Whalley Parish Council

3/2012/0179 Proposal: Outline application for a residential development for the
elderly, comprising of 38 bungalows and 40 retirement apartments.

Location: land at Accrington Road Whalley

OBSERVATIONS/OBJECTIONS

© Harrison & Pitt
Residential Units at Accrington Road
Whalley
for Briery Homes
PROPOSED SITE PLAN
1637-040 P4 1:500 @ A2

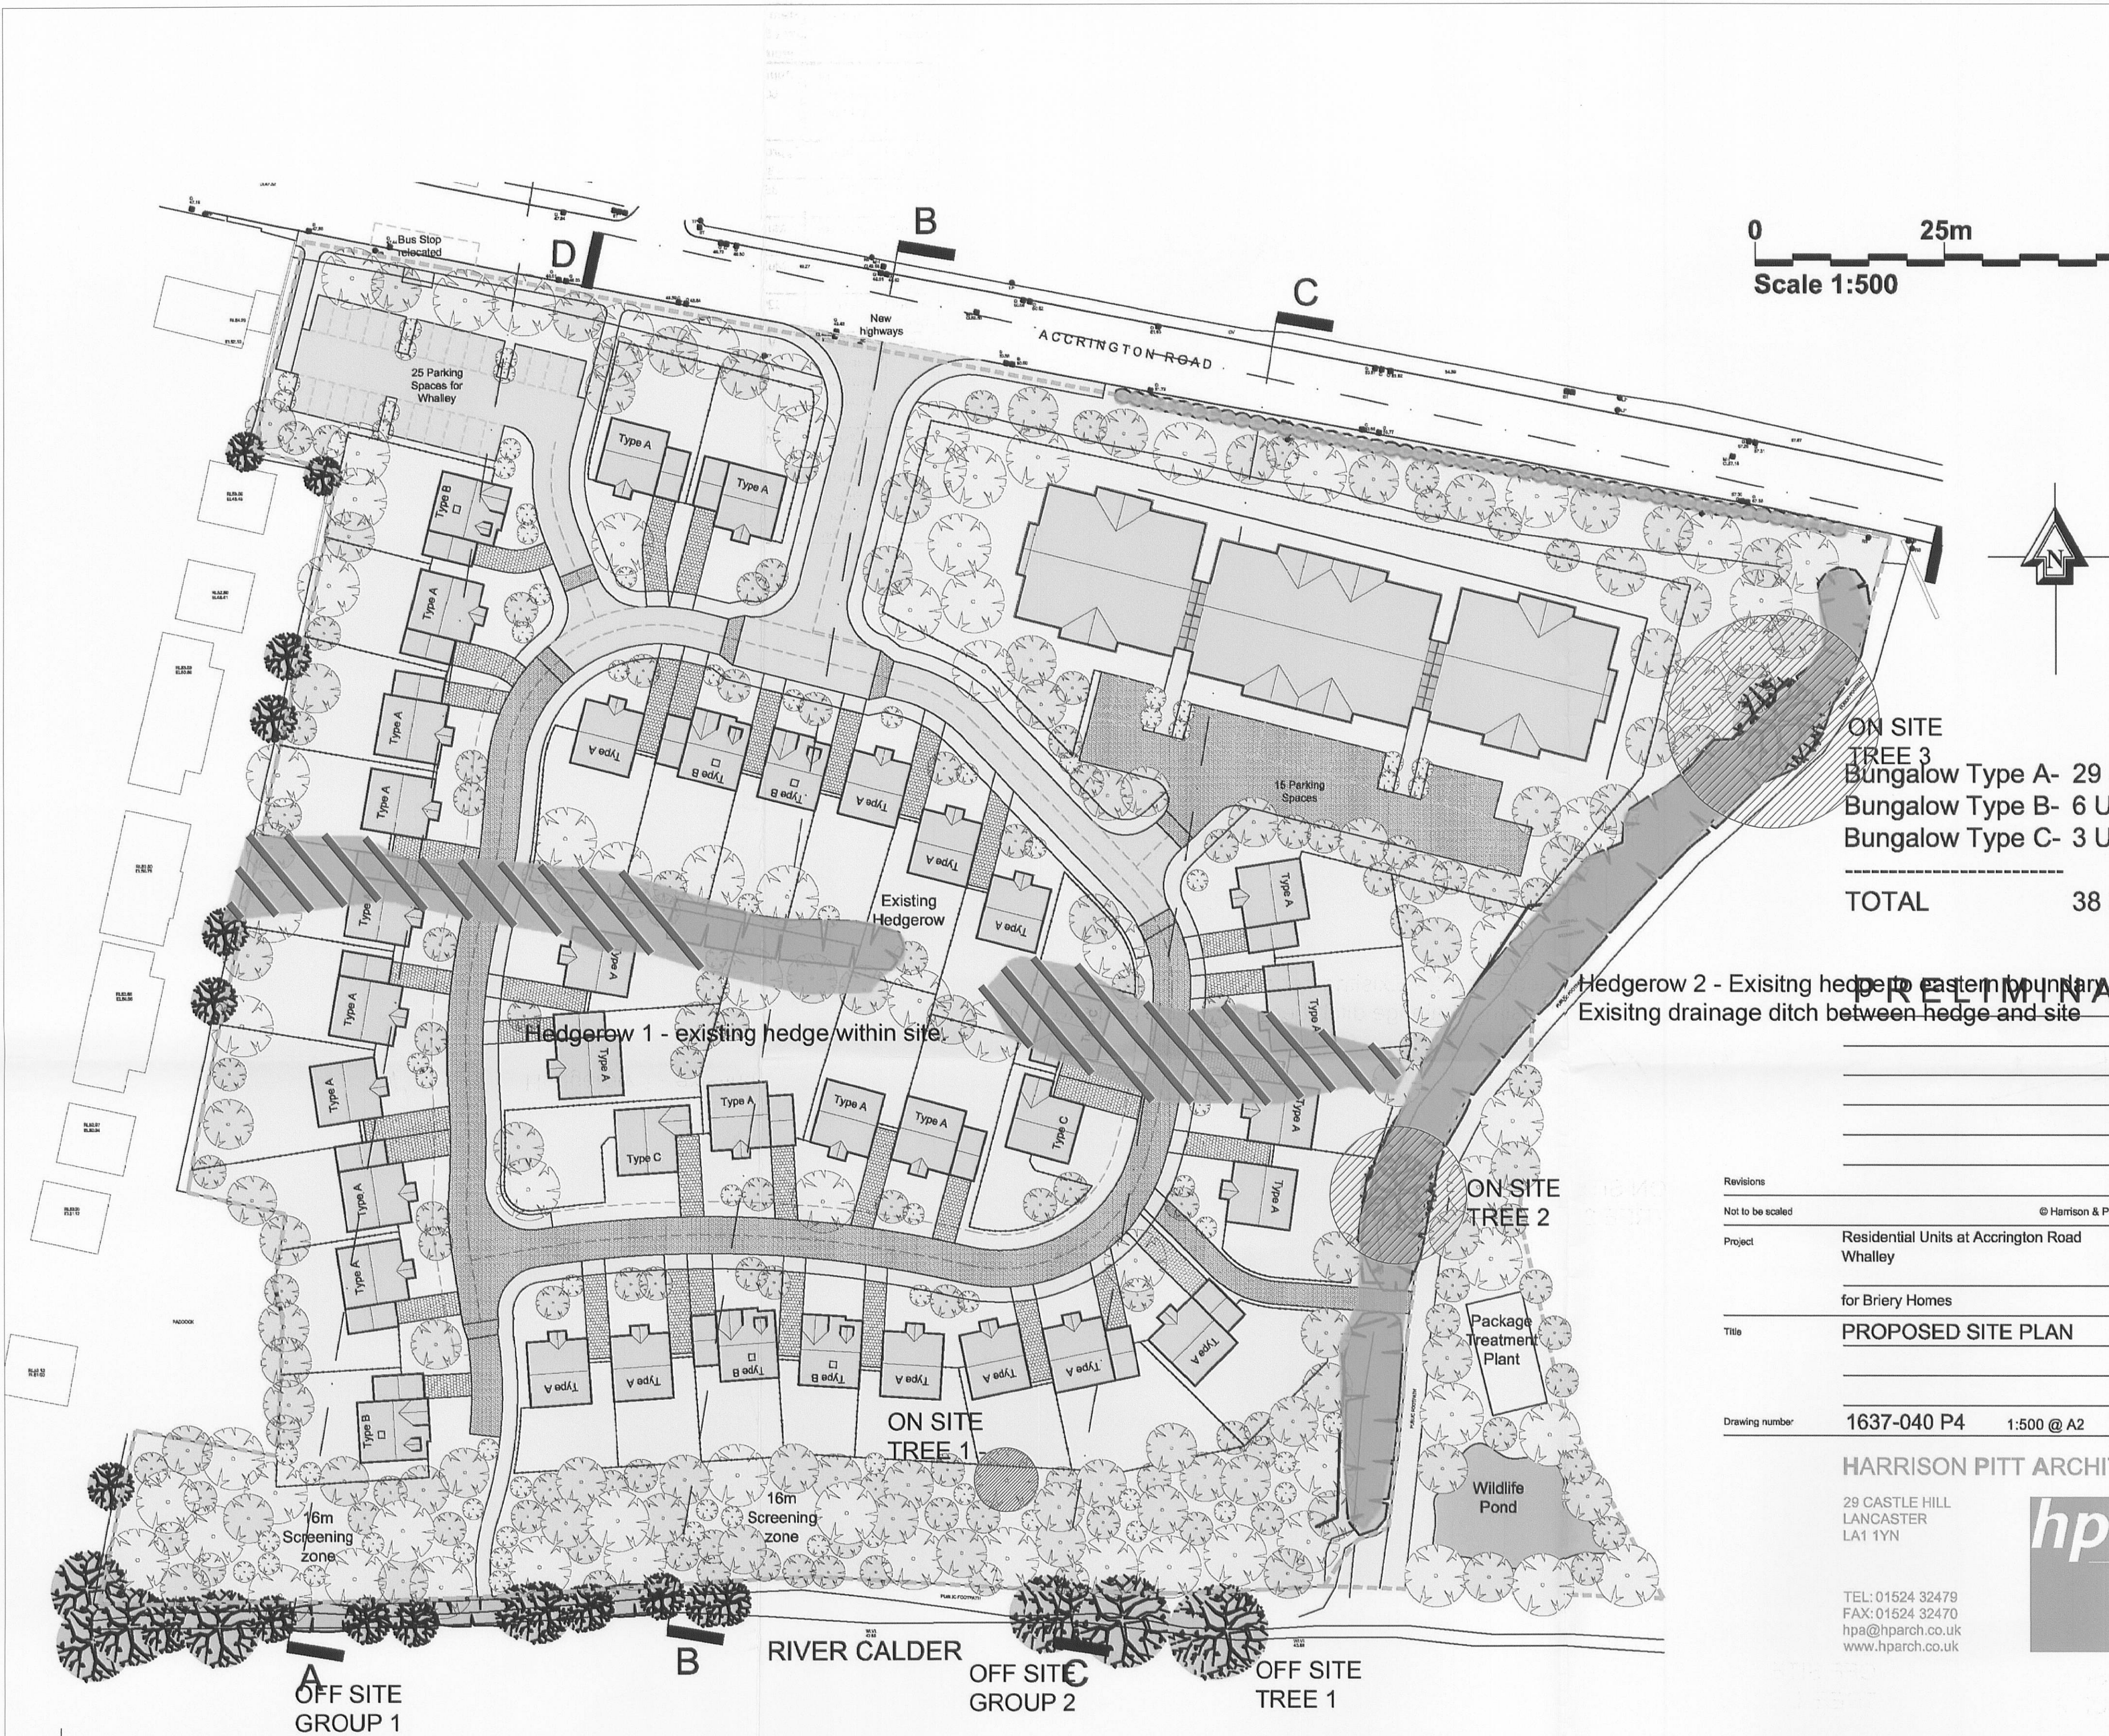
-the inadequacy of parking provision of 15 spaces for 40 apartments – the parish council are very surprised that it claimed that this is in accordance with standards.
